**M1 Pacific Motorway extension to Raymond Terrace (SSI 7319)
Advice on the Environmental Impact Statement (EIS)**

Thank you for the request for advice from Public Authority Consultation (PAE-24749572), requesting the review by the NSW Environment Protection Authority (EPA) of the Environmental Impact Statement (EIS) for the proposed M1 Pacific Motorway extension to Raymond Terrace (Application SSI-7319).

ATTACHMENT A: EPA COMMENT ON EIS FOR M1 PACIFIC MOTORWAY EXTENSION TO RAYMOND TERRACE (SSI 7319)

Location: L07 - 179 Old Maitland Road, Hexham

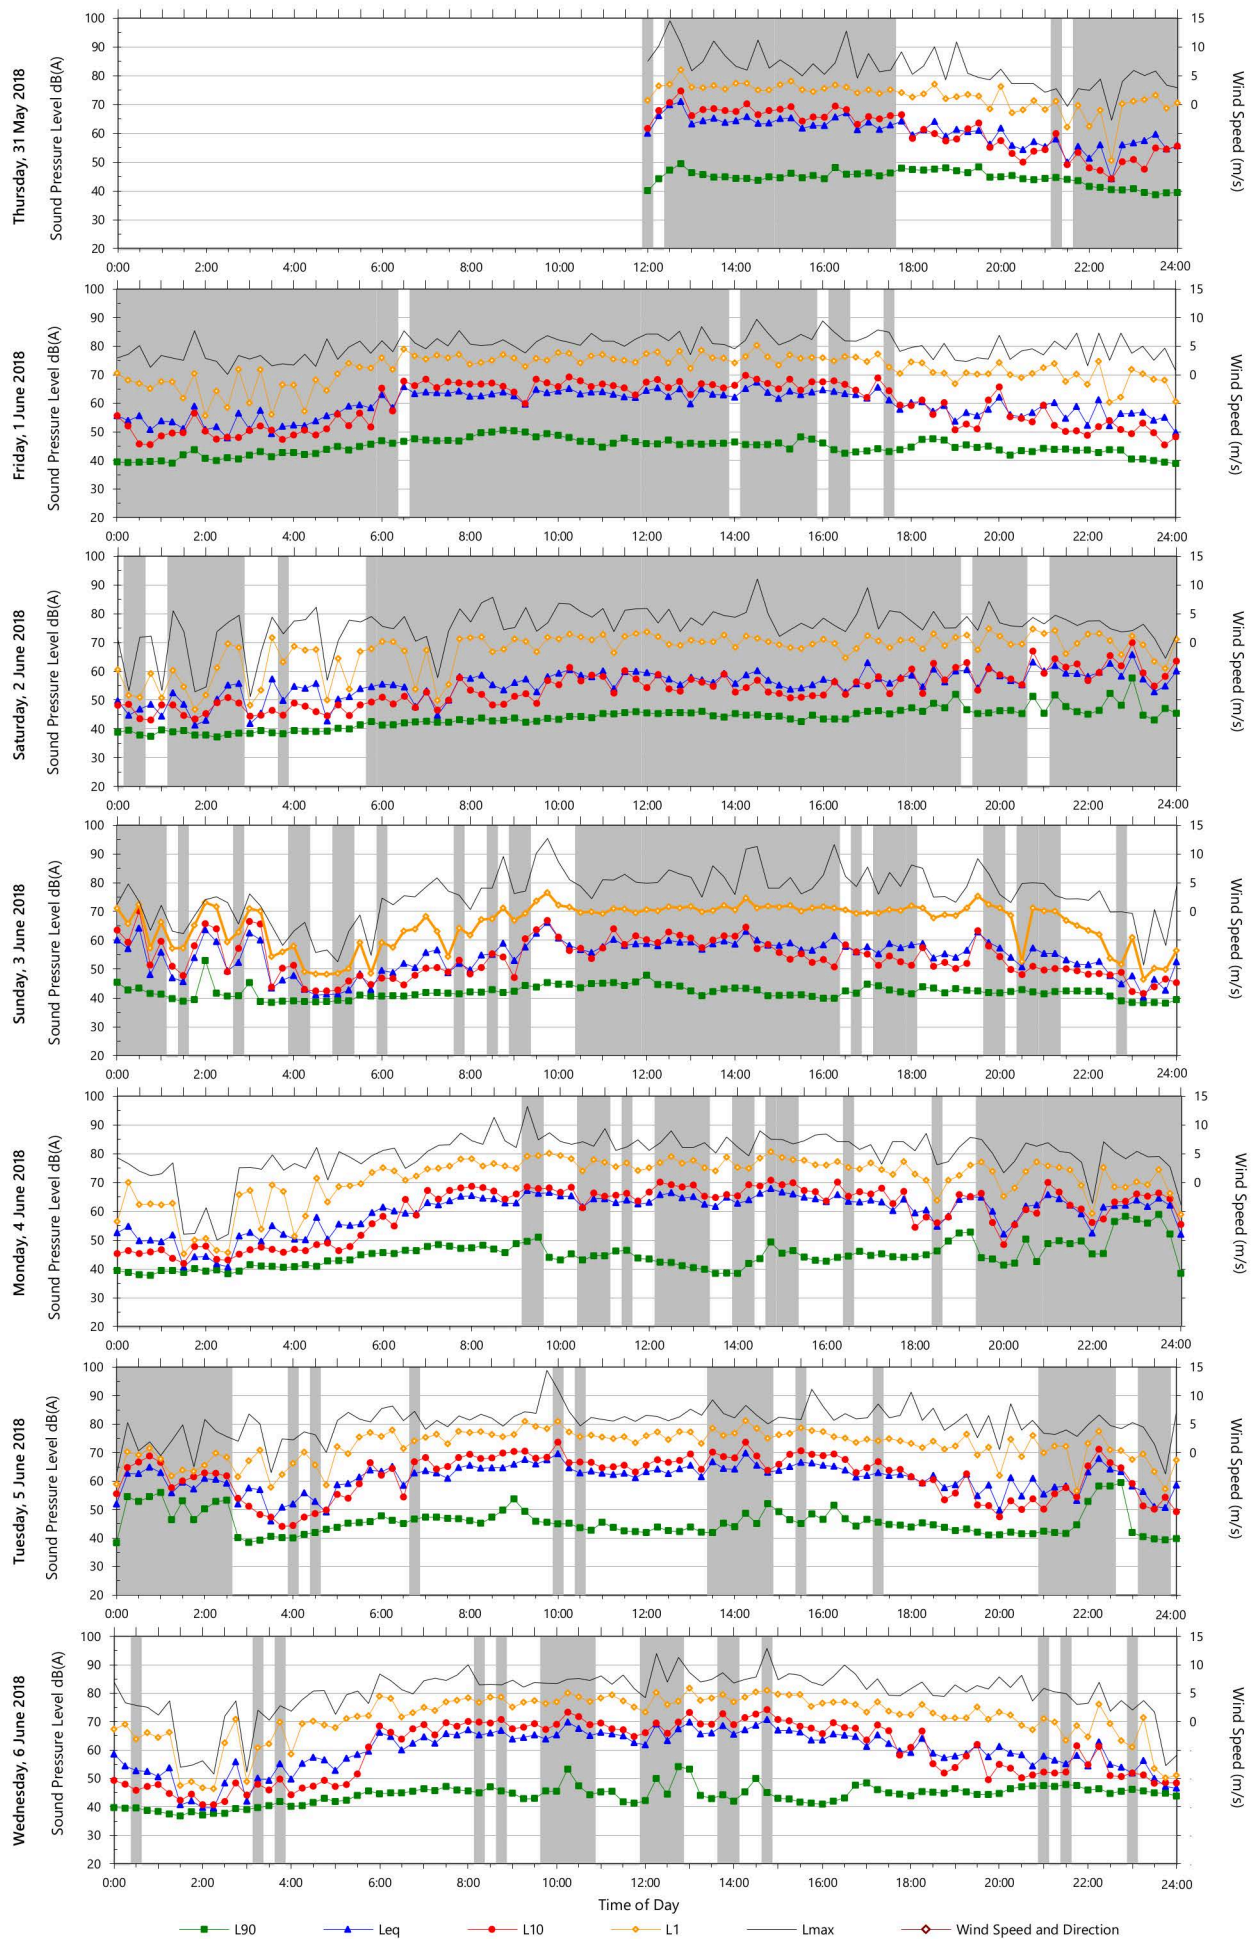
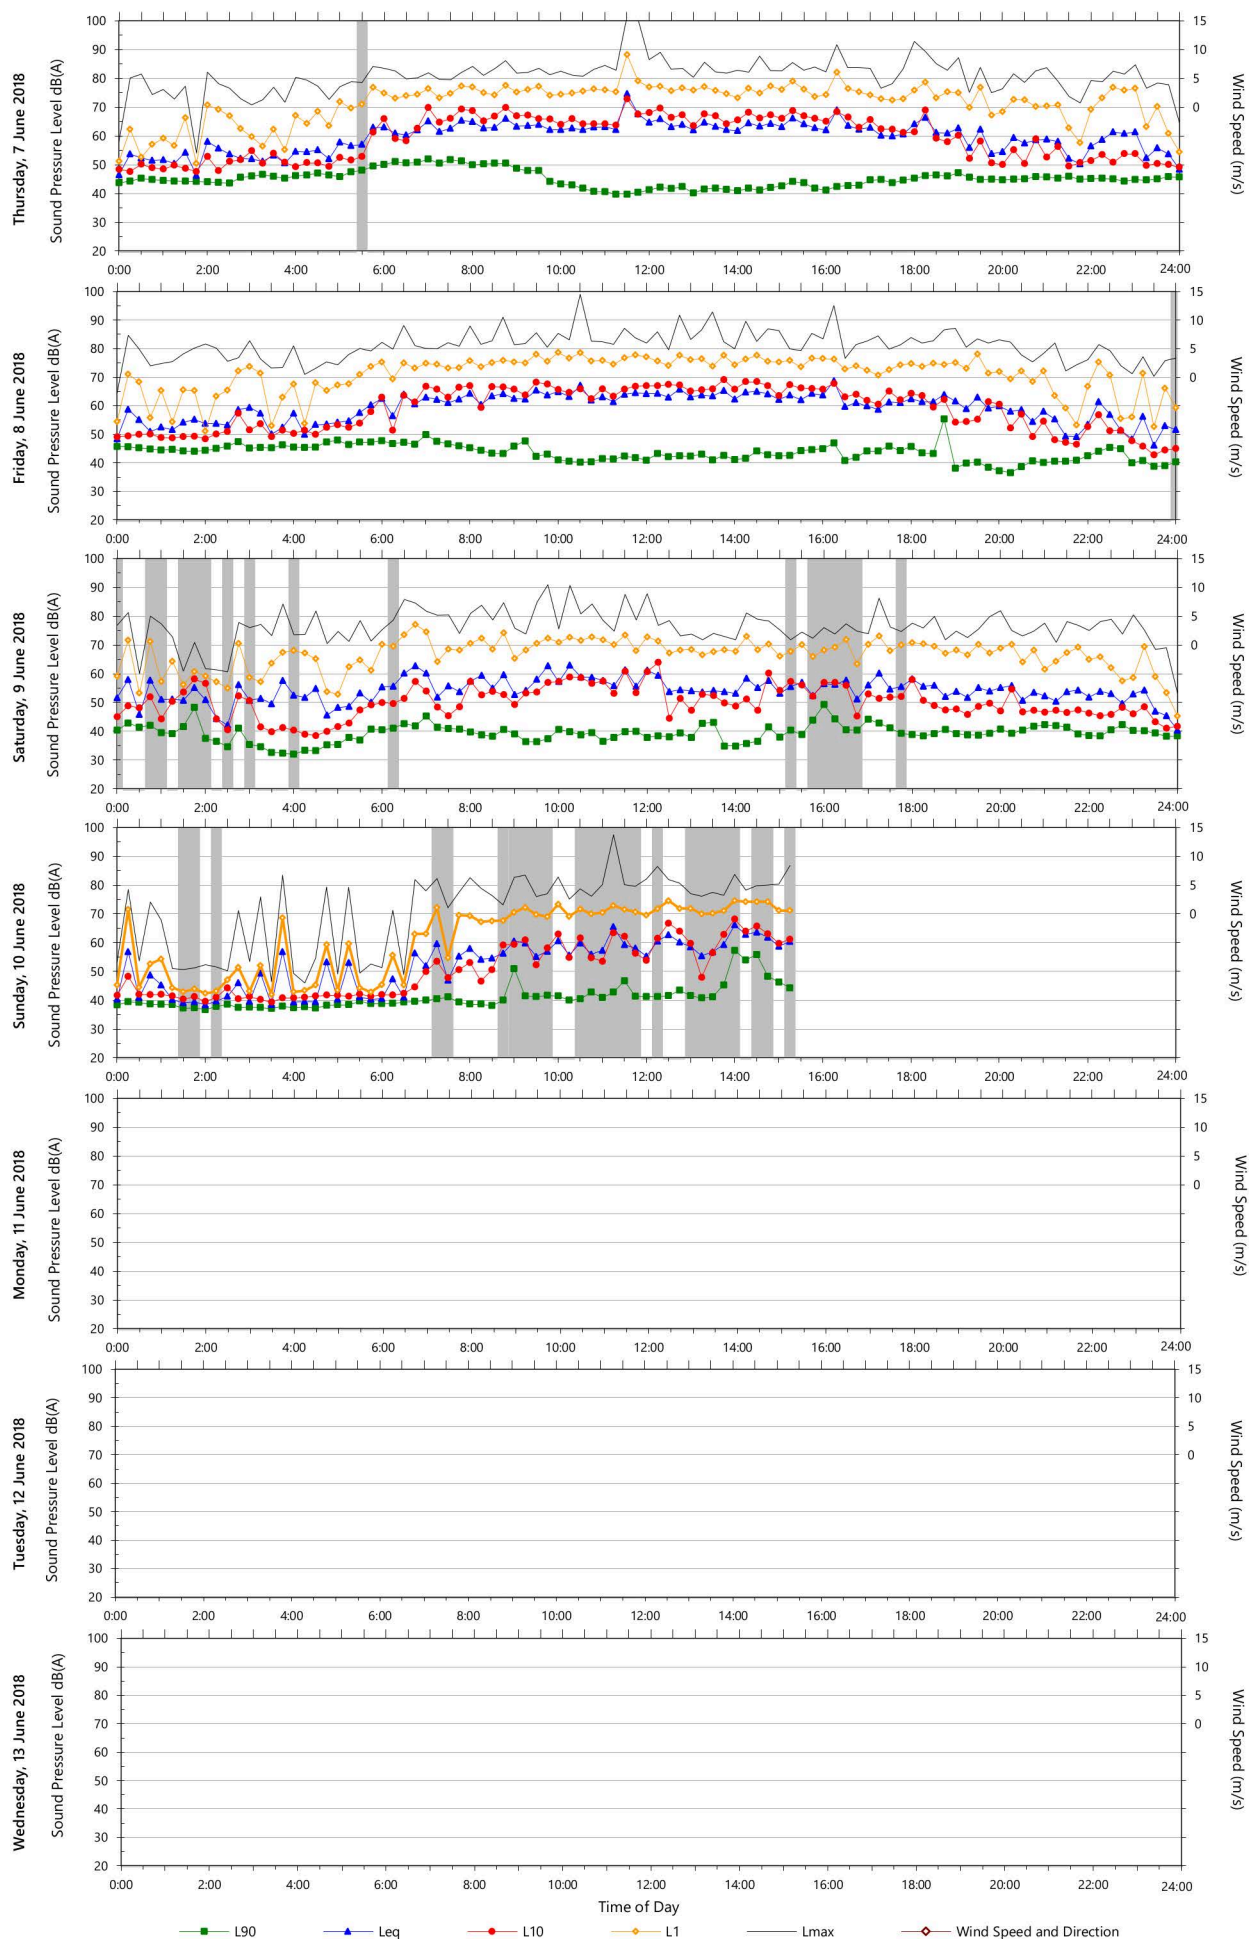
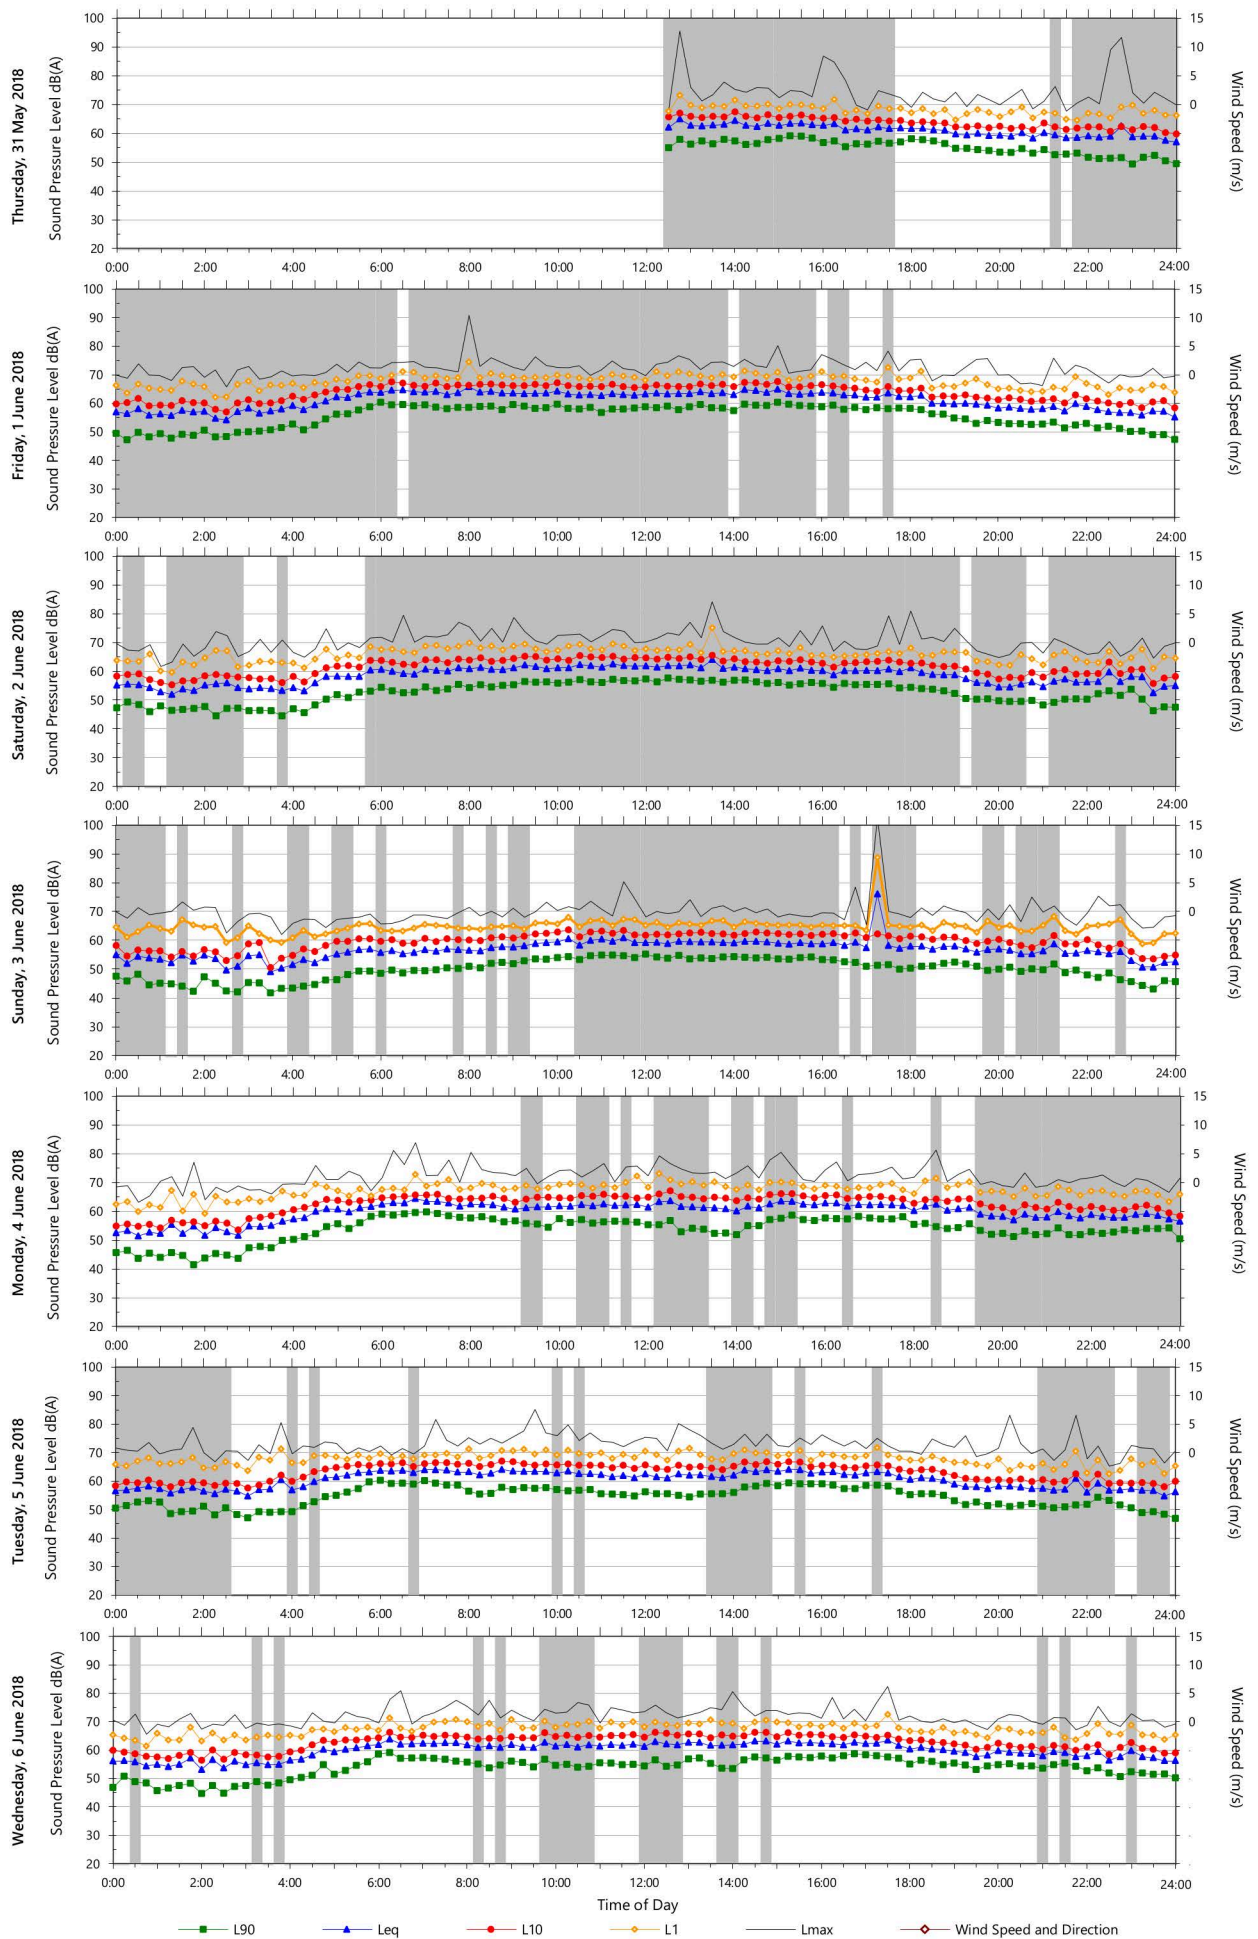
A review of the noise monitoring graphs in NIA Appendix B.2 indicates that further justification for the adequacy of noise monitoring presented or additional information is required.

A significant amount of data appears to have been excluded due to either inclement weather or extraneous noise. The EPA is concerned that the extent of data excluded means that it may not be representative of long term background noise levels, and therefore its suitability to be used to establish reliable noise management levels could be called into question.

Locations L01 to L014 (inclusive) appear to have no more than 5 and in some cases less than 3 valid periods out of the total monitoring duration. Locations L15 to L20 appear to be less affected, however there it is still not clear if sufficient valid data has been presented.

Fact Sheets A and B in the Noise Policy for Industry (NPfI) set out the EPA's requirements for establishing background noise levels. Due to the amount of data excluded, it is currently not clear if these requirements have been satisfied nor if sufficient valid data has been presented in order to establish representative background noise levels.

Noise monitoring was also conducted in 2016 for the purposes of measuring road traffic noise. Due to the amount of data excluded at Locations L13 to L20, further justification is needed that the remaining data, after invalid samples were excluded, provides sufficient amount of data to enable a representative calculation of the traffic noise descriptors.

The proponent reviews the noise monitoring data in the NIA in the context of the monitoring requirements set out in the NPfI and for each location and either:

- Provide a justification and demonstrate that the requirements of the NPfl have been fulfilled; or
- Provide additional data that fulfills the monitoring requirements in the NPfl.

The EPA also recommends that the proponent either:

- Provides justification and demonstrate that the data presented for road traffic noise descriptors is sufficient to be representative; or
- Provides additional valid data.
